Proposal: Partial discharge of Condition 6 (parking and manoeuvring areas) (Phase 8C Only) of 19/00446/F

- 2.1. This application seeks to partially discharge Condition 6 (parking and manoeuvring areas) of planning reference 19/00446/F in respect to Phase 8C only.

4.1 OCC Highways - Objection

TITLE: UPPER HEYFORD PARCEL D2b (PHASE 8)
 DETAILS: TRACKING

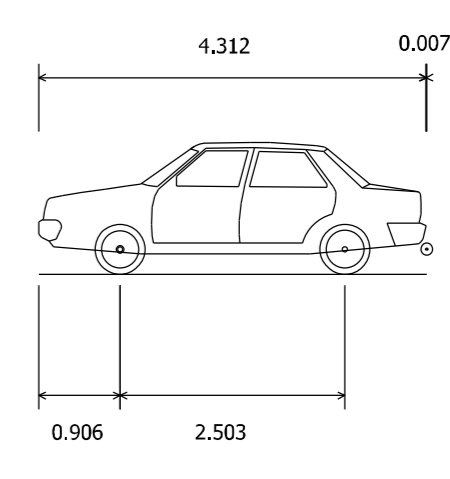
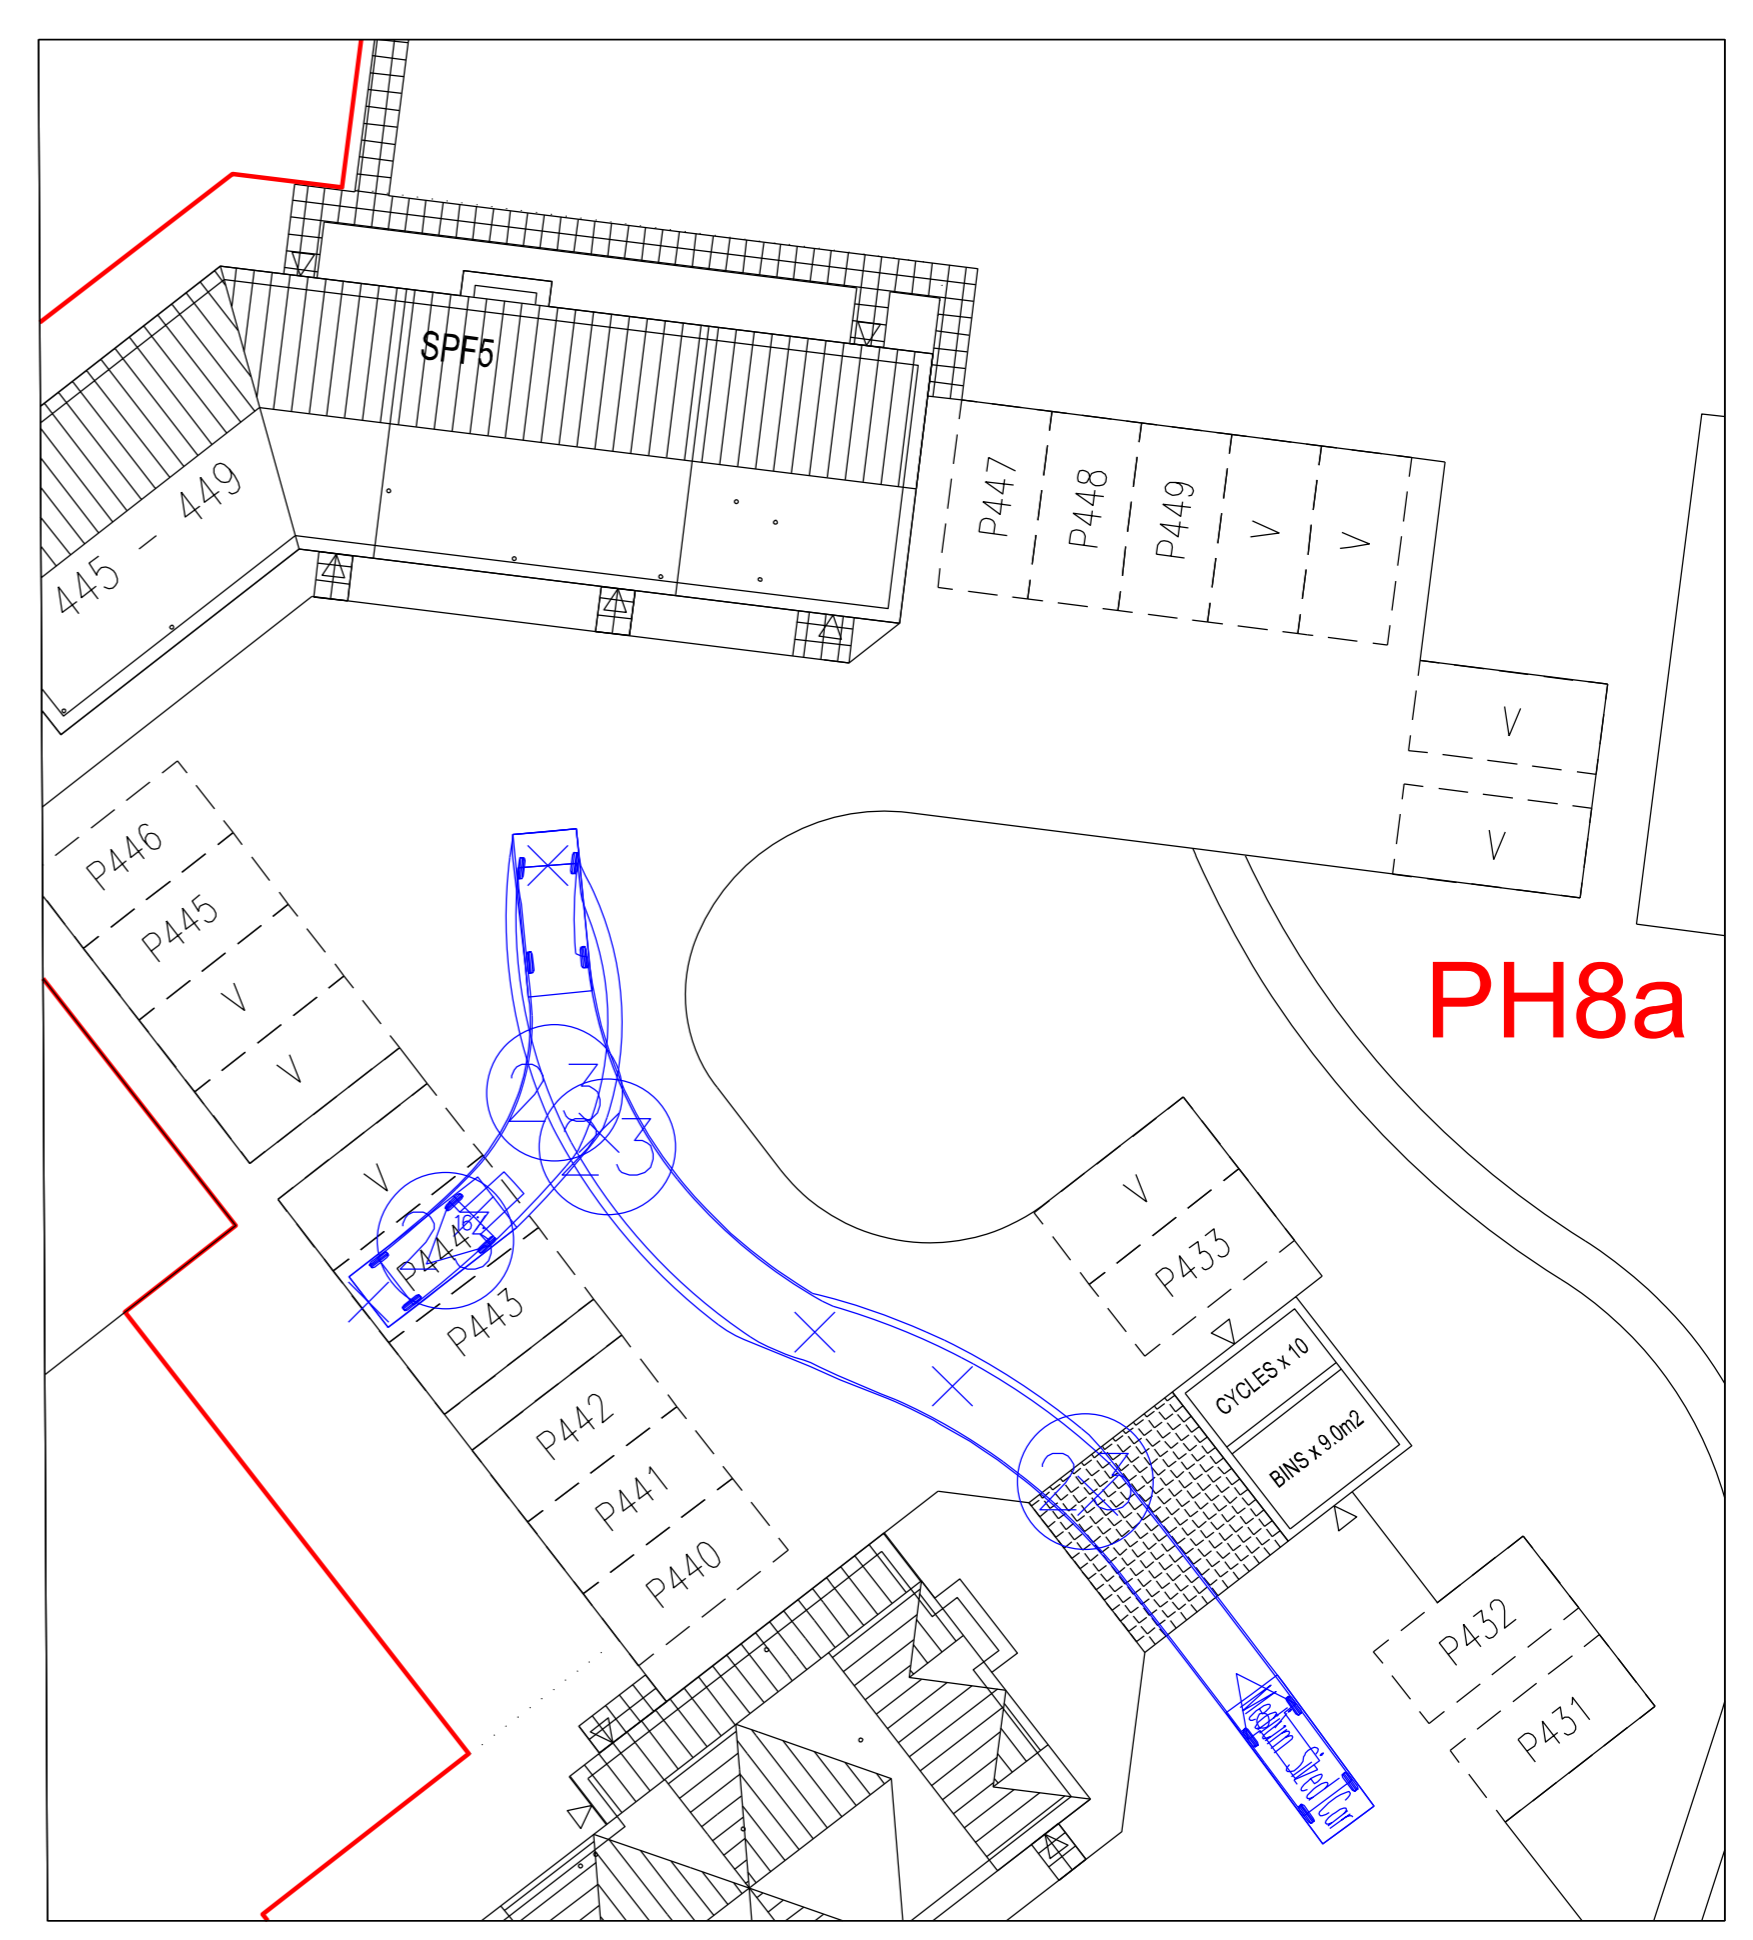
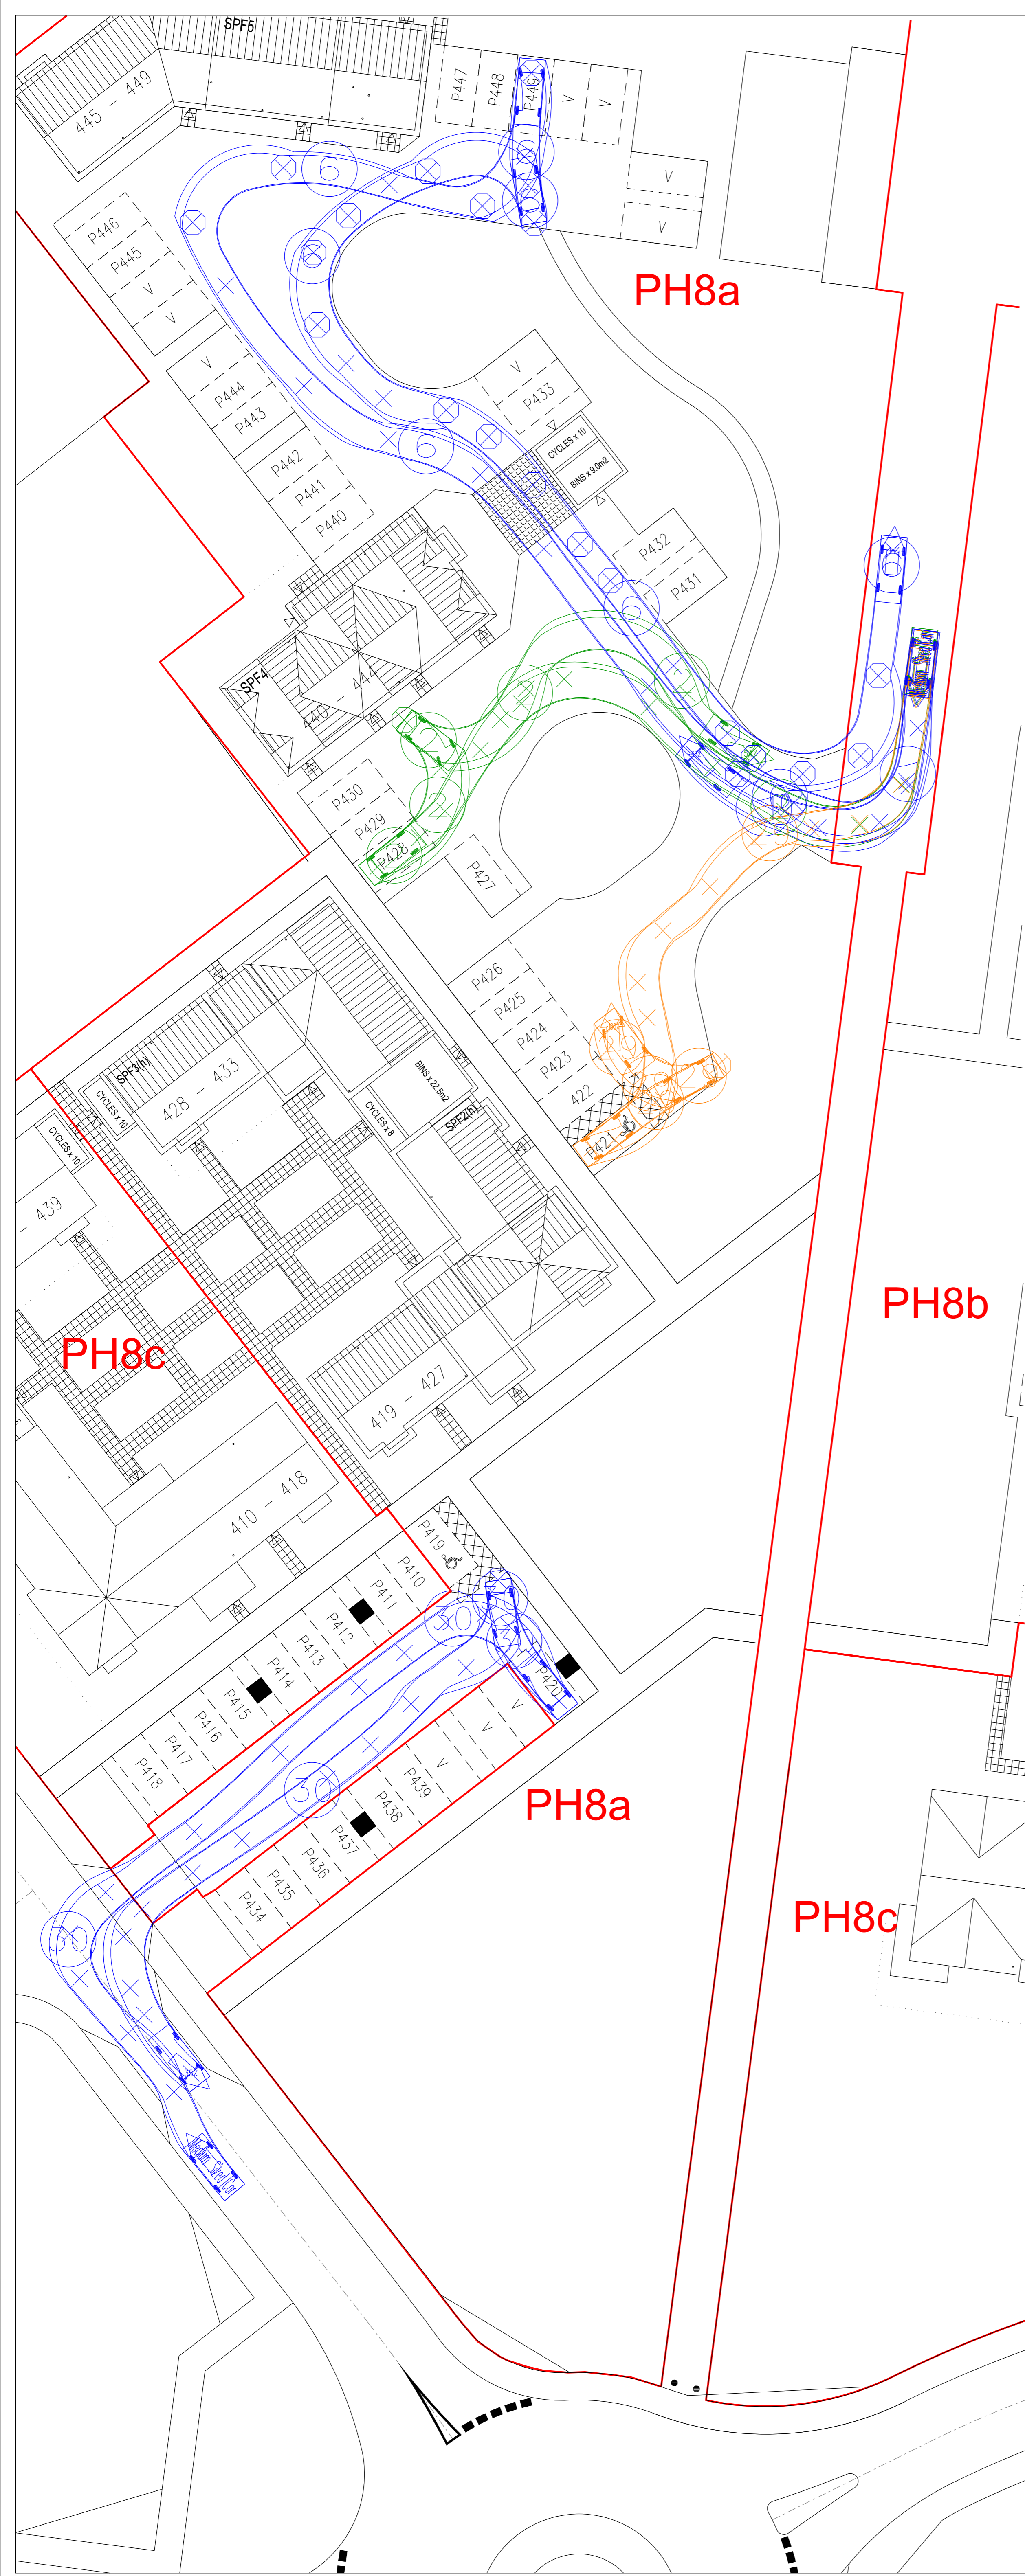
- When assessing the tracking diagrams for the parking and manoeuvring areas outlined, the tracking vehicle was observed crossing over into adjacent spaces or verges when entering and exiting parking spaces. The infringements are located in the following plans:
 - PH8A space 420.
 - PH8A - vehicle crosses onto verge close to footway.
- Vehicle tracking must show vehicles making the manoeuvres without crossing into adjacent parking spaces or verges.
- The design and layout for Phase 8C (Trident area) has been technically approved for the s38 design.

- 5.1 As referenced above this submission seeks to partially discharge condition 6 in relation to phase 8C only.
- 5.2 Condition 6, wherein the parent permission requires the submission and approval of full specification details of the parking and manoeuvring areas to serve the dwellings. In response to the above the applicant has specified by means of a series of detailed drawings, the construction, layout, surfacing and drainage associated to the respective parking and manoeuvring areas to serve the dwellings.
- 5.3 It is noted that OCC Highways have objected to the submission on the basis that the tracking vehicle is observed crossing over into a small part of one parking space (no. 420) and vehicle tracking also crosses onto part of a verge close to, but not onto a footway on one other part of the site.

5.4 However, it is also noted that the final design, including these parking and manoeuvring areas, have already been agreed by OCC as Highway Authority within their approved S.38 design. As such, given the minimal tracking issues identified above and the fact that the wider S.38 design has already been approved, the proposals are deemed consistent and to be acceptable in the interests of highway safety, by ensuring the provision of adequate off-street car parking and manoeuvring areas, in accordance with the requirements of condition 6.
